From: Philip William [REDACTED]
Sent: 27 July 2021 11:25
To: Planning <Planning@arun.gov.uk>
Subject: Objection to planning application EP/69/21/PL

I am writing to object to the planning application EP/69/21/PL for a 3 bedroom bungalow to be built east of 18 Beechlands Court. I live locally and have regularly visited a close relative that resides in one of the flats in Beechlands Court, for many years. So I feel that I know the road and residents very well.

SITE PLAN

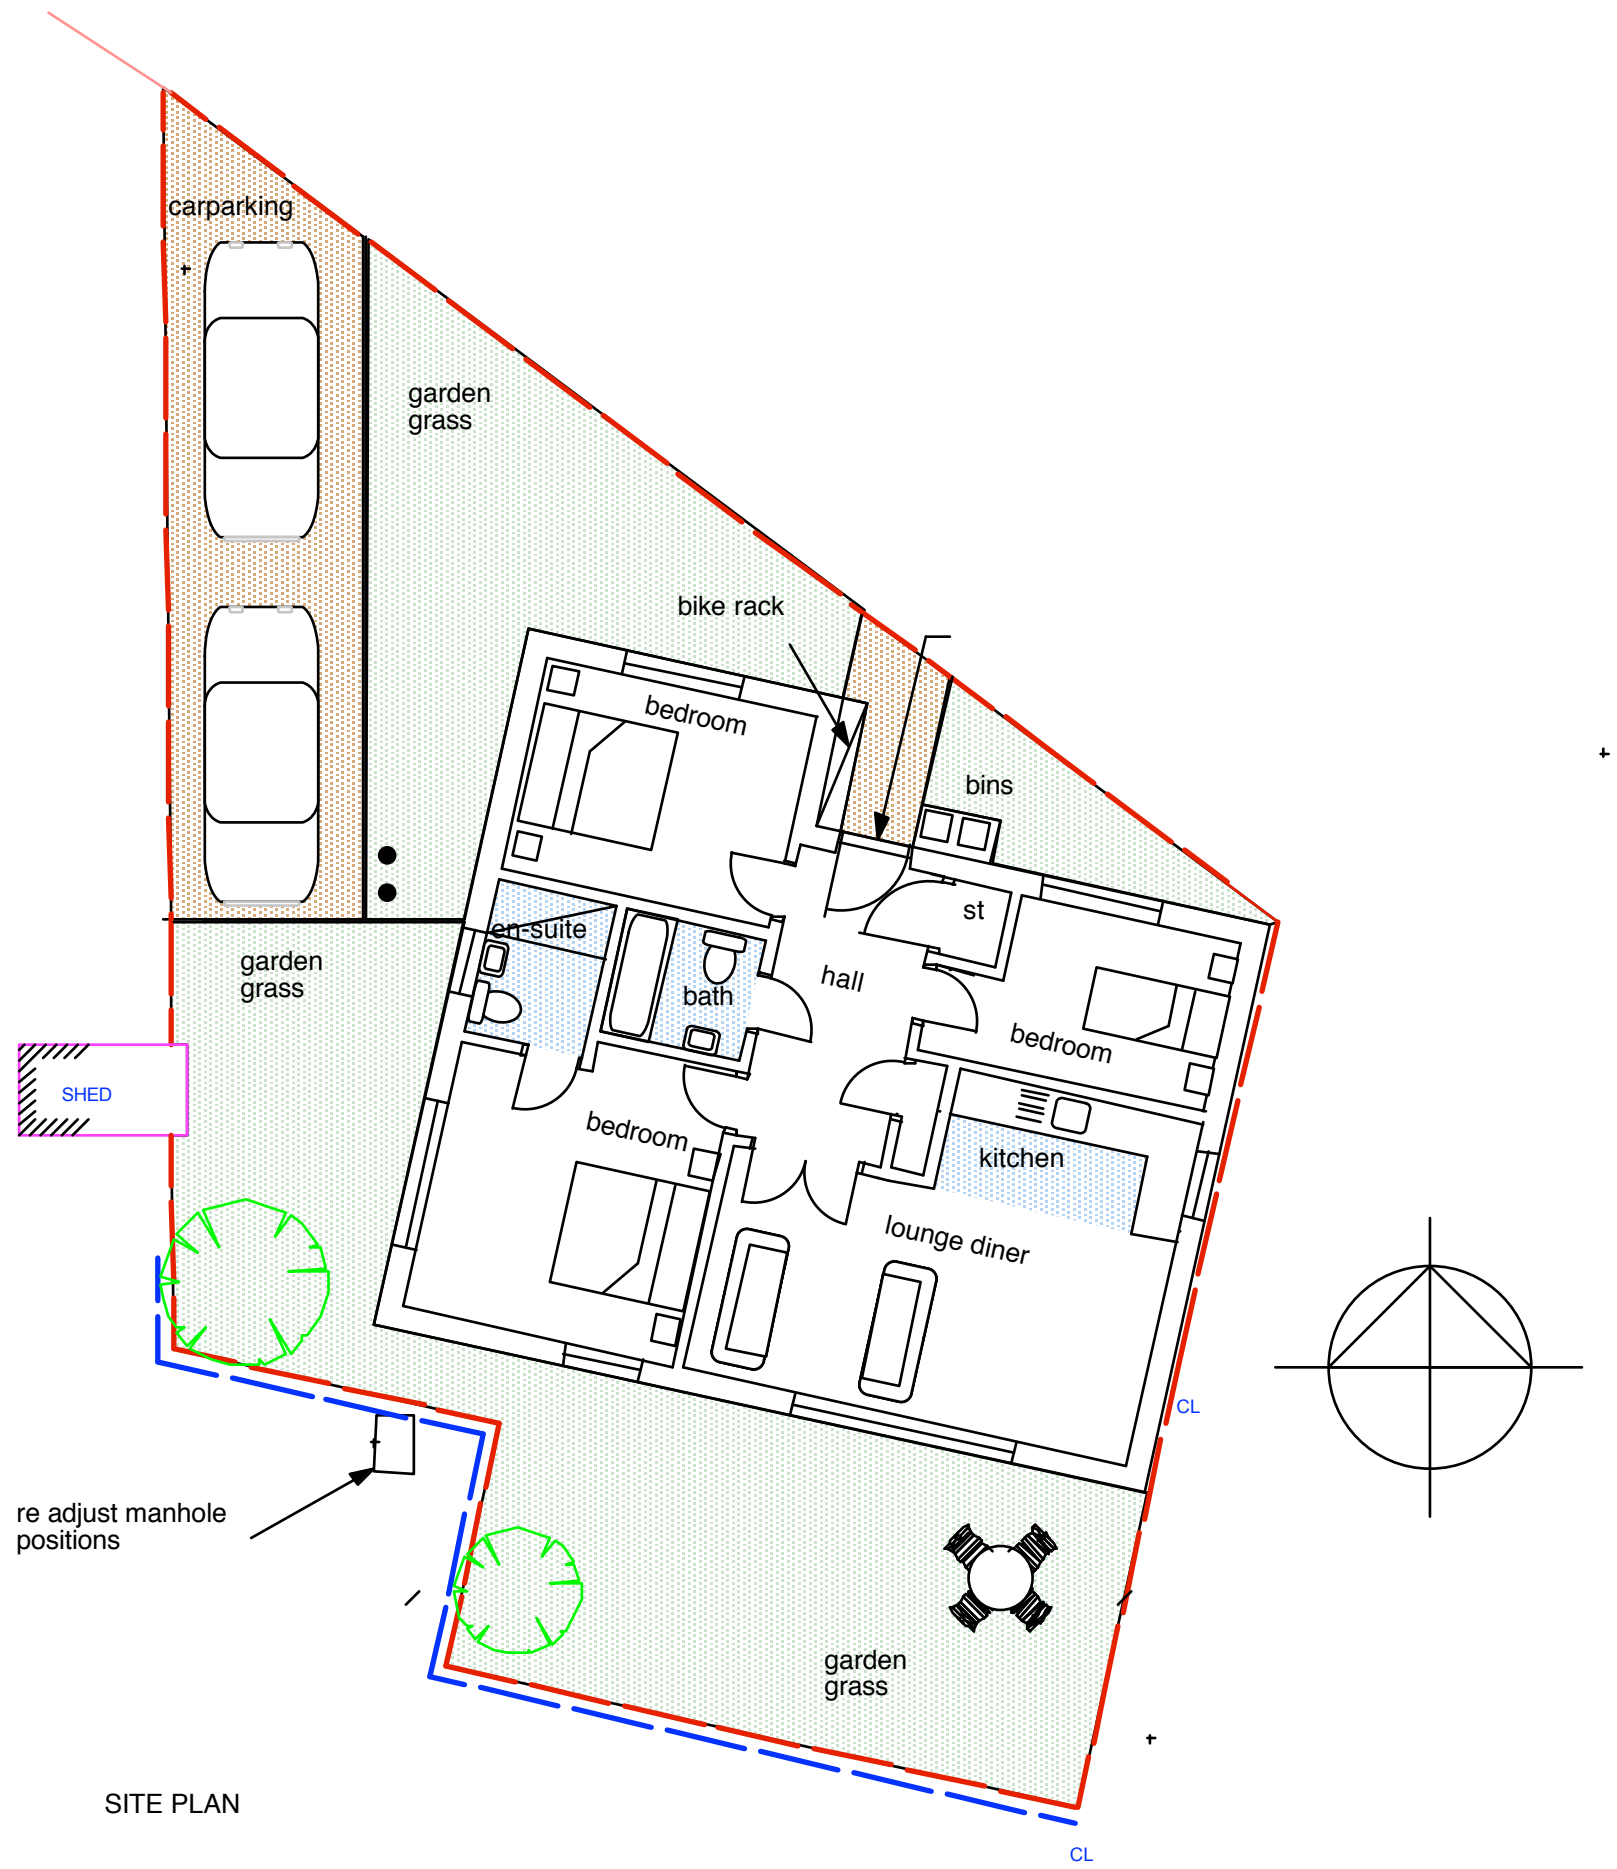
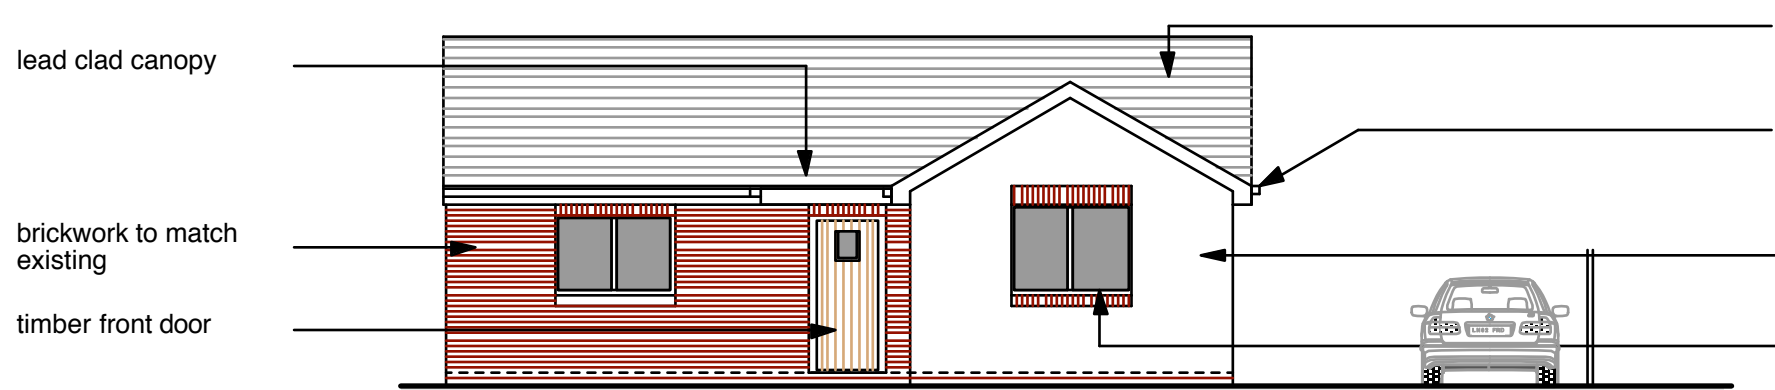
There currently arent enough parking spaces for the residents of Beechlands Court and in the evenings and weekends, it is very hard to find any parking spaces at all. Looking at the plans for the bungalow, it seems that the

current off road parking for 18 Beechlands Court will be taken away. This, combined with potential guests visiting the residents of the bungalow from time to time will cause further competition for parking spaces. There are some elderly residents that live in Beechlands Court and it will be very difficult for them to walk any kind of distance, to their property, especially with shopping etc.
